**WEST SUSSEX COUNTY COUNCIL
STRATEGIC PLANNING CONSULTATION**

**SUBJECT: BR/179/14/PL - New 3/4 bed dwelling & minor alterations to no.33 Shelley Road.
Resubmission of BR/306/13**

33, Shelley Road, Bognor Regis, PO21 2SN

scale
 1:100 1:200 date 06.2014 drawn
 drawing ref number
 site ground and roof floor plans 2858A/3/5

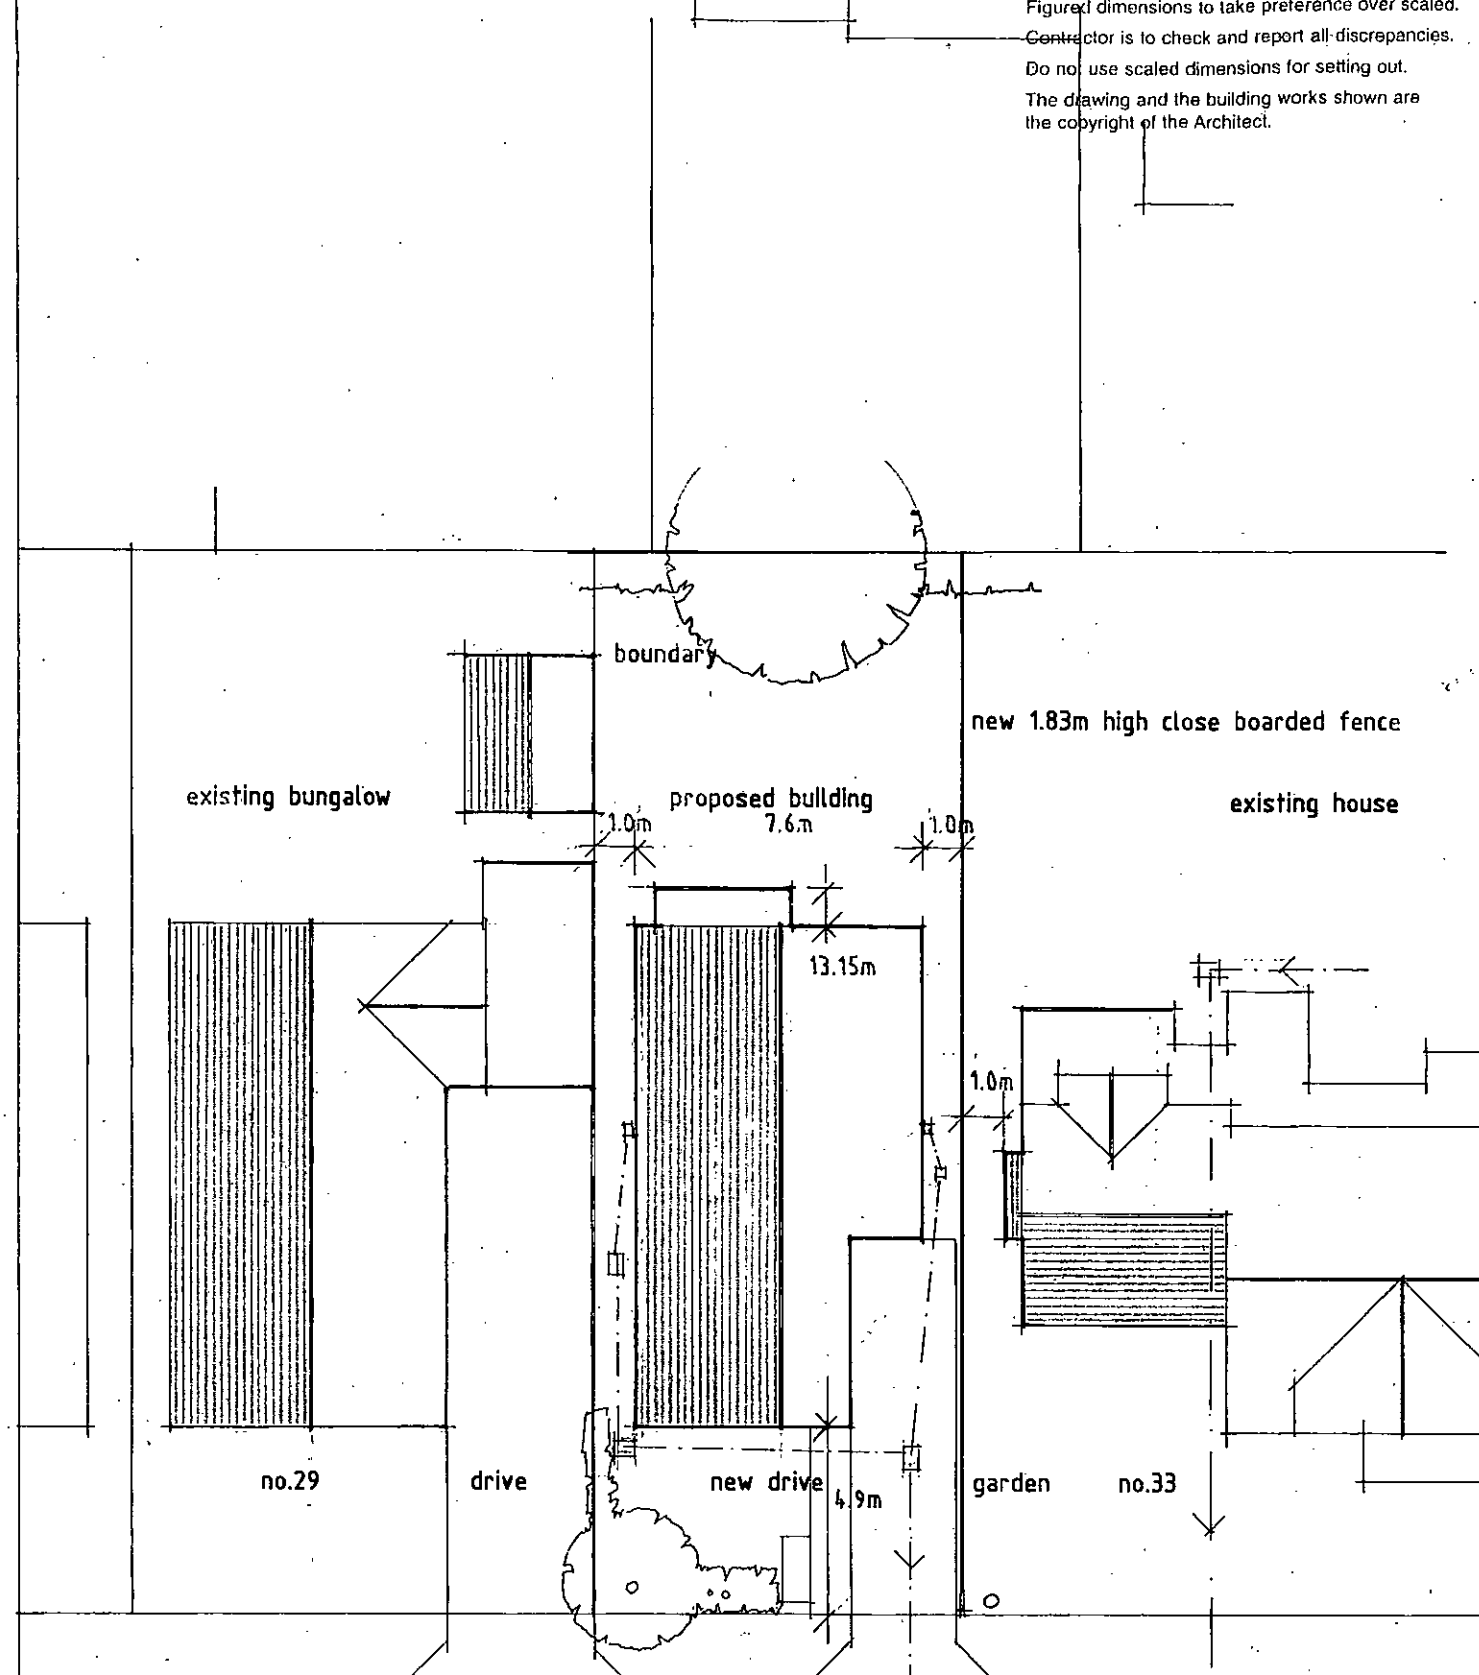
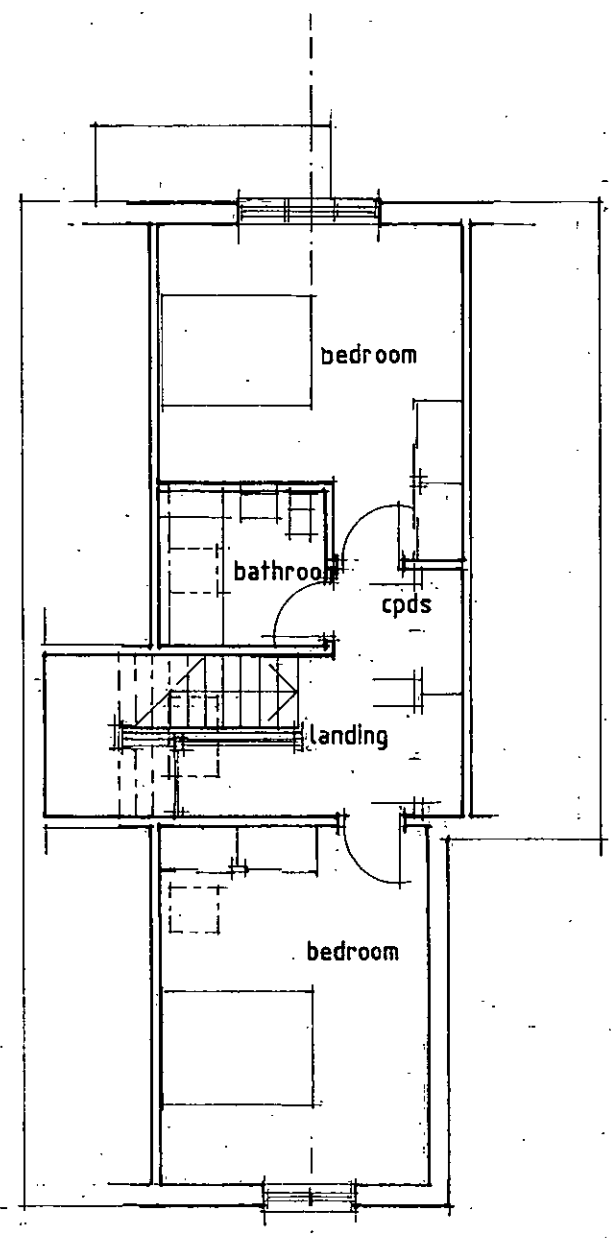
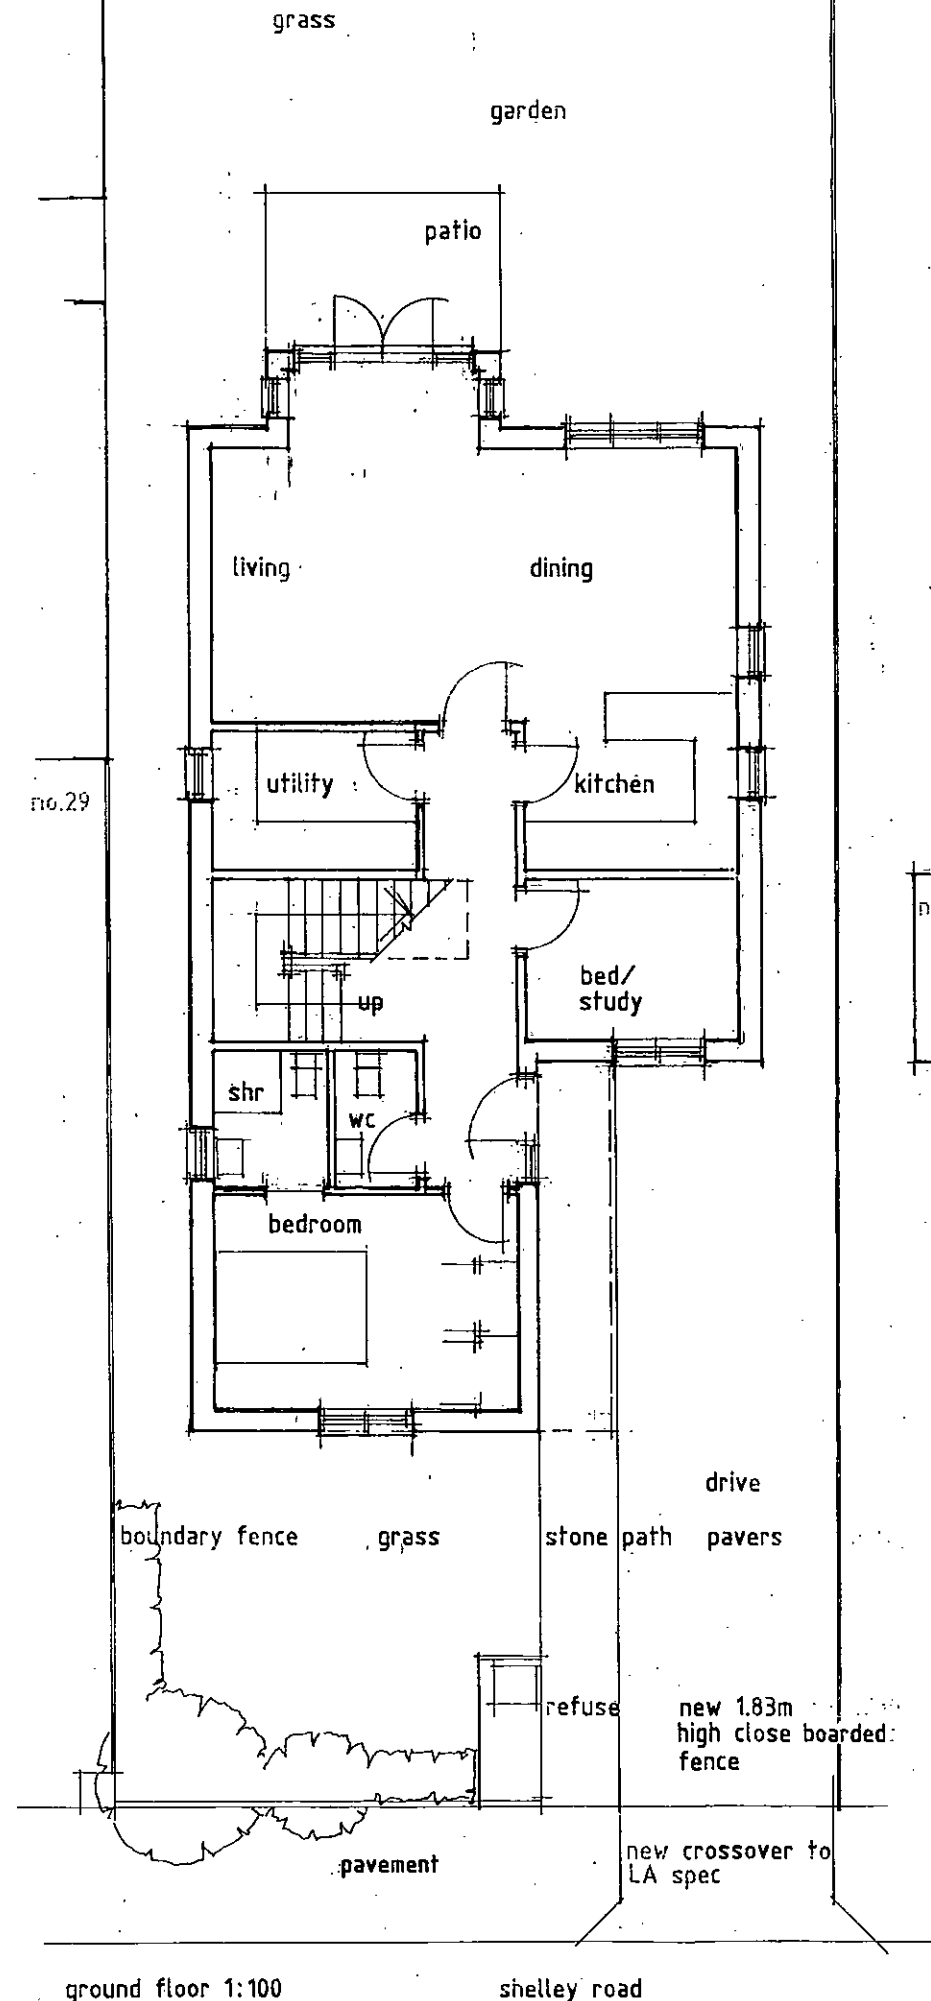
Two off street car parking spaces will be provided in tandem via a new vehicular dropped crossing. Whilst a turn on site is not provided I would note that the proposed access arrangement does seem to be consisted with many other vehicular access arrangements along Shelley Road. I have checked the most recently available verified accident records, which reveals there have been no personal injury accidents in the vicinity of the existing point of access. Therefore no concern would be raised to the formation of the new point of access.

It would be advised that all front boundary treatment abutting Shelley Road remain below 0.6 metre in height, this is to ensure maximum available visibility for vehicles and pedestrians. As a minimum I would requested that 2 x 2 pedestrian visibility splays, at each side of the proposed point of access, inasmuch as is under control of the applicant, be secured via condition whereby no obstruction within these splays be above 0.6 metres in height. This may have an impact on the proposed front boundary treatments.

Two vehicular car parking spaces would meet the anticipated demand. The applicant should provide 2 secure and covered cycle parking spaces in the interests of sustainability.

- Access
- Cycle Parking (2 Cycles)
- Construction plant and materials storage
- Front Boundary Treatments below 0.6 metres or Pedestrian Visibility as described above
- Vehicle Parking
